Gate Burton Energy Park

EN010131

Applicant Responses to ExA's Third Written Questions (ExQ3)
Document Reference: 8.28
November 2023

Figure 5 - Archaeological Mitigation Site 16 and 20m Buffer Zone

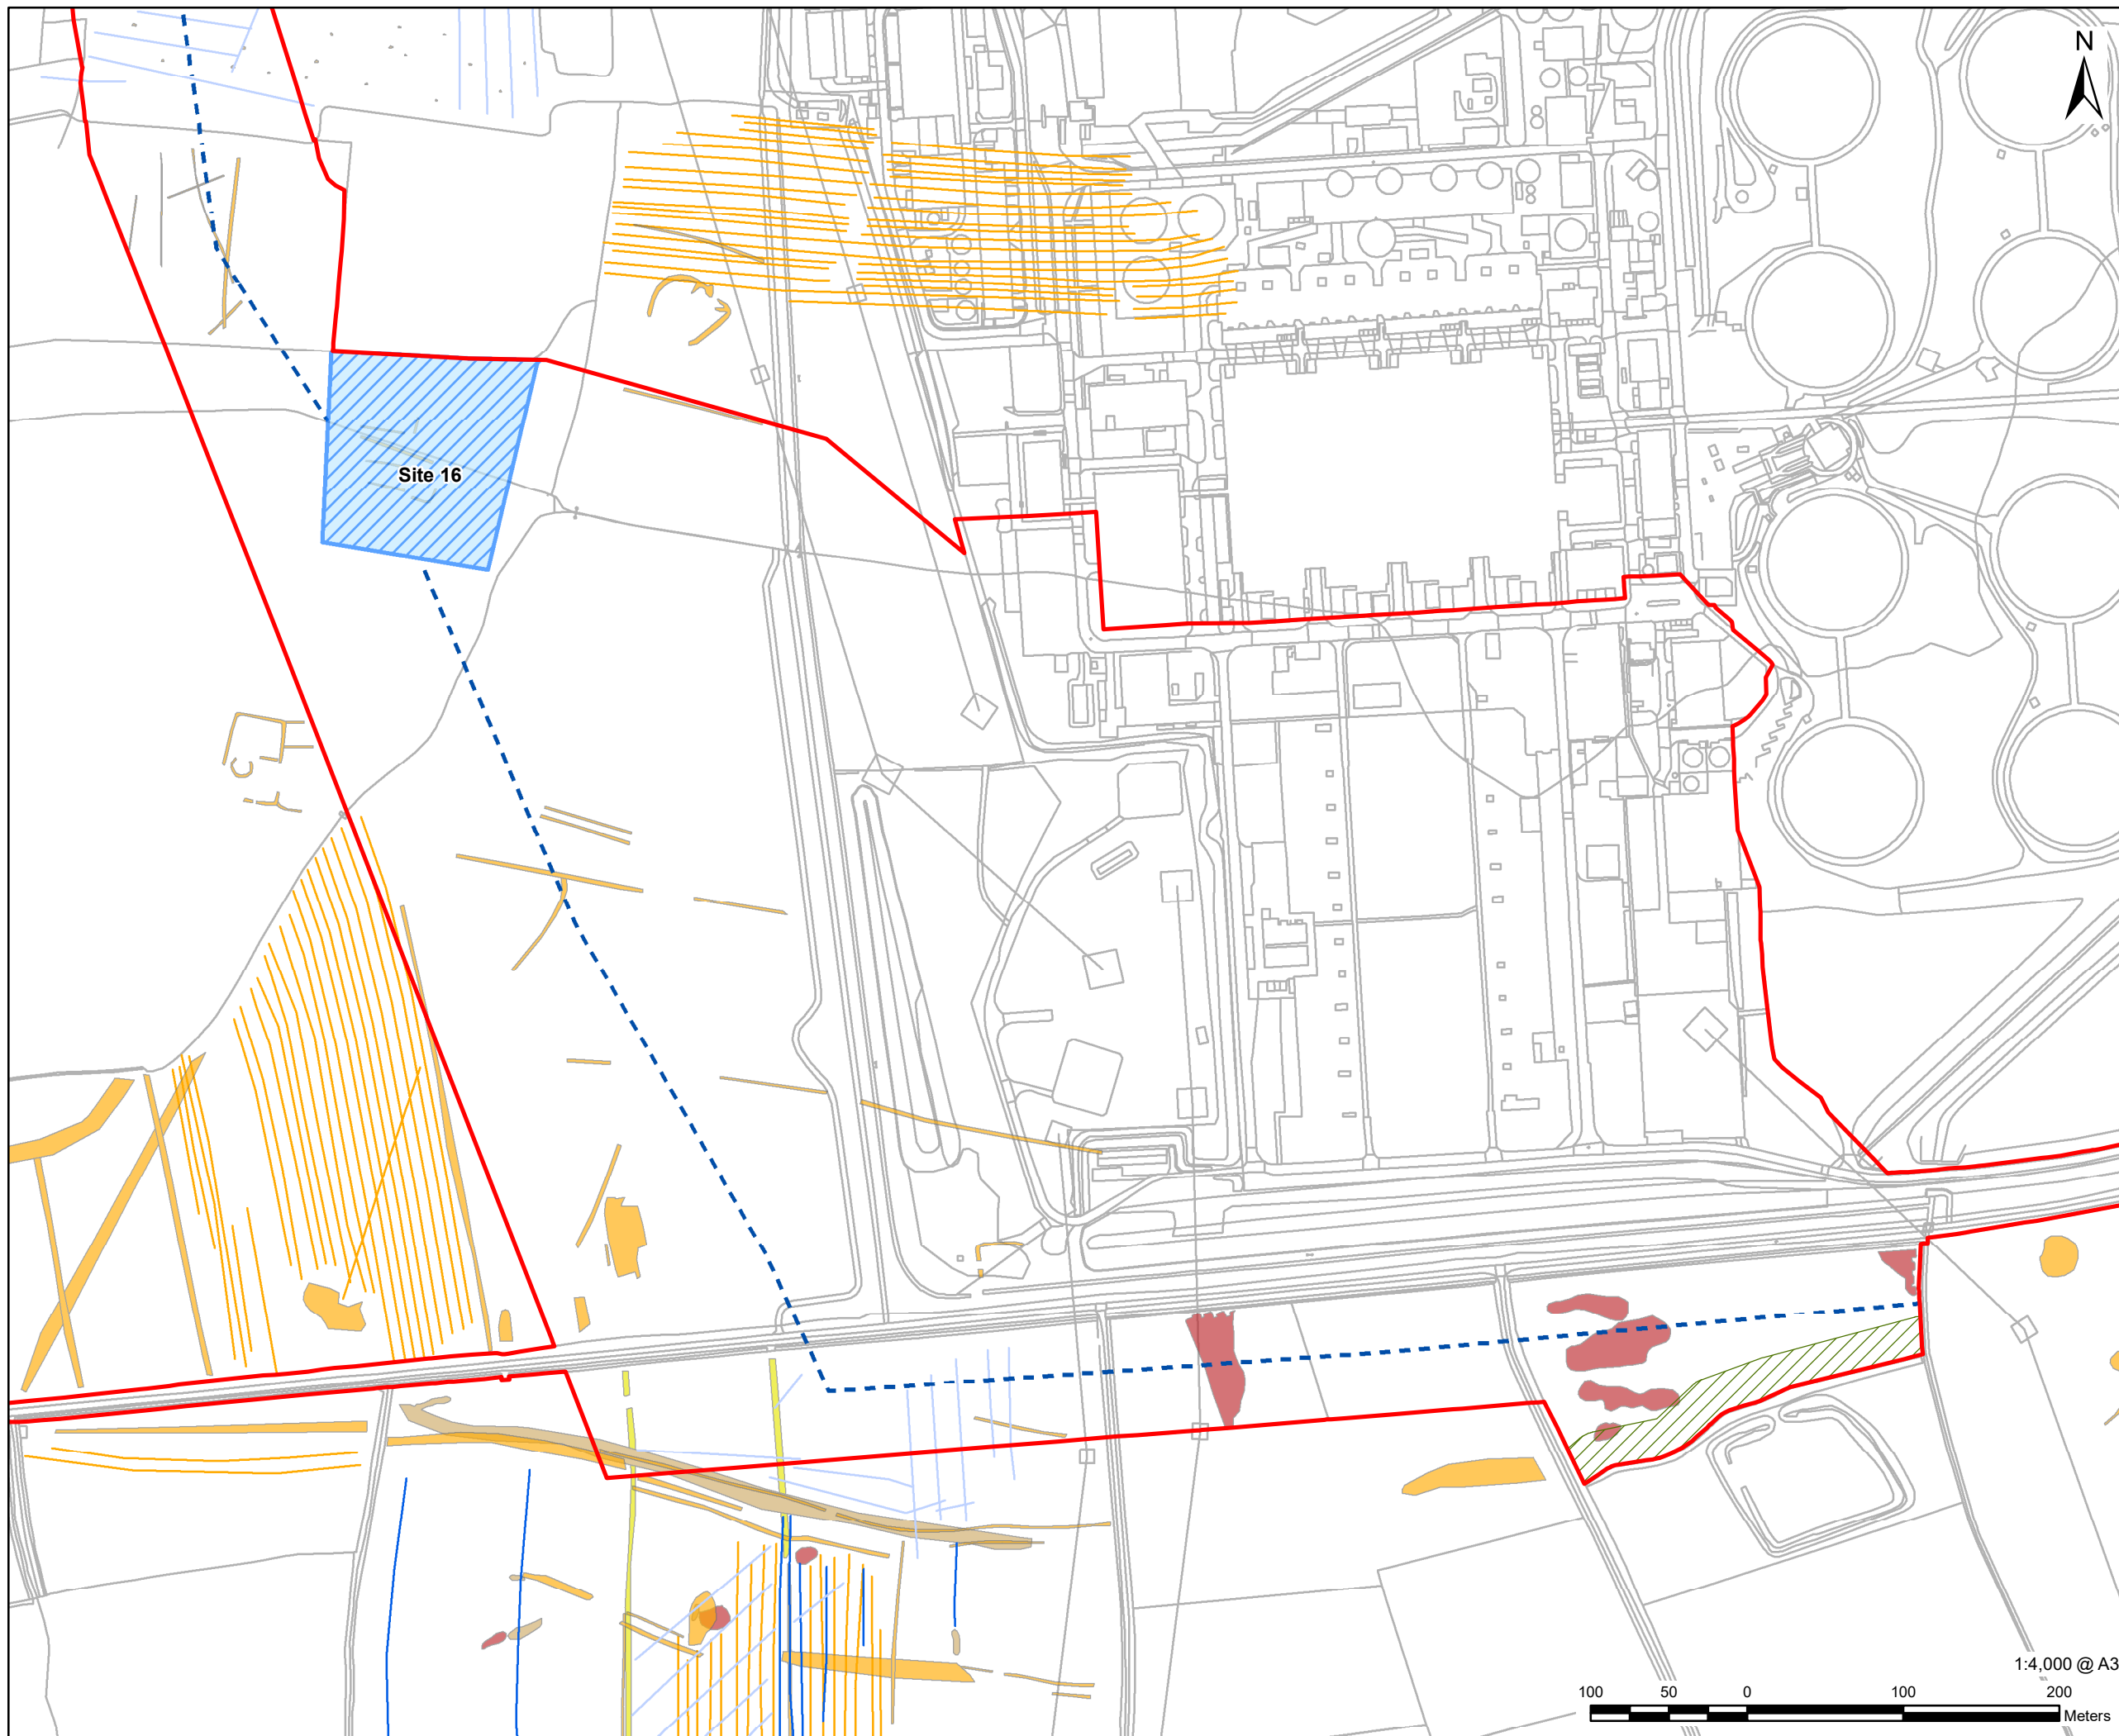
Question Number	Respondent	Question Summary	Applicant Response
			<p>the extended Order limits. In addition, Historic England have agreed to a 20m buffer zone along the northern boundary of the Scheduled Monument Fleet Plantation moated site (NHLE 1008594). No construction activities will be undertaken within this buffer zone. These mitigation strategies have been set out in the updated Appendix 7.6 Archaeological Mitigation Strategy Part 2 Grid Connection Corridor submitted at Deadline 5.</p>
<p>2. Biodiversity, Ecology and Natural Environment (including Habitats Regulations Assessment (HRA))</p>			
Q3.3.1	The Applicant	<p>Electromagnetic field effects (EMF) on fish:</p> <p>The Environment Agency [REP4-063] has suggested a Risk Assessment in relation to EMF is produced centred on the grid connection corridor crossing of the river Trent to understand the risks during the operation of the Proposed Development and whether it is likely to have any impacts on fish including cumulative risks with other schemes.</p> <p>The EA also suggest this should be added to the potential impacts in areas of discussion so that the Statement of Common Ground can be reissued once the matter has been resolved.</p> <p>1) The Applicant should carry out the requested Risk Assessment and submit it into the Examination at the next deadline, deadline 5. In preparing the Risk Assessment this should be undertaken taking account of input from the Environment Agency and Natural England, with any advice or comment they have before the document is finalised.</p>	<p>1) Please refer to Appendix A, which includes the Risk Assessment in relation to EMF. The Risk Assessment was shared with the Environment Agency and Natural England on 9th November for comment, however no feedback was received. The Risk Assessment confirms that the probability of adverse effects of EMF from cables buried beneath watercourses for the Gate Burton Energy Park and cumulatively with West Burton, Cottam and Tillbridge on fish is extremely low; will be negligible in the wider context of the watercourses; and is therefore not significant.</p> <p>2) Mitigation in the form of burying the cable a minimum of 5m below the lowest point of the riverbed of the River Trent is included within the Outline Design Principles [REP4-004] which is secured by Requirement 5 of the Draft DCO [REP4-023]. No further mitigation is required.</p> <p>3) The Risk Assessment presented in Appendix A confirms that the probability of adverse effects of EMF from cables buried beneath the River Trent for the Gate Burton Energy Park and cumulatively with West Burton, Cottam and Tillbridge on fish is extremely low and therefore, not significant. As such, there are no impact pathways which may affect protected sites, notably the Humber Estuary Special Area of Conservation (SAC). The Applicant's Habitats Regulation Assessment [APP-223/7.2] did not identify any European Sites within the studies search area, i.e., where they may be impacted by the proposed Solar and Energy Storage Park and/or Grid Connection Corridor and concluded that will be No Significant Effects to European Sites either from the construction, operation and decommissioning of the Scheme or in combination with other plans and projects. The Risk Assessment confirms that there are no impact pathways from EMF on fish and therefore, the conclusion of the HRA remains valid and no further updates are required.</p>
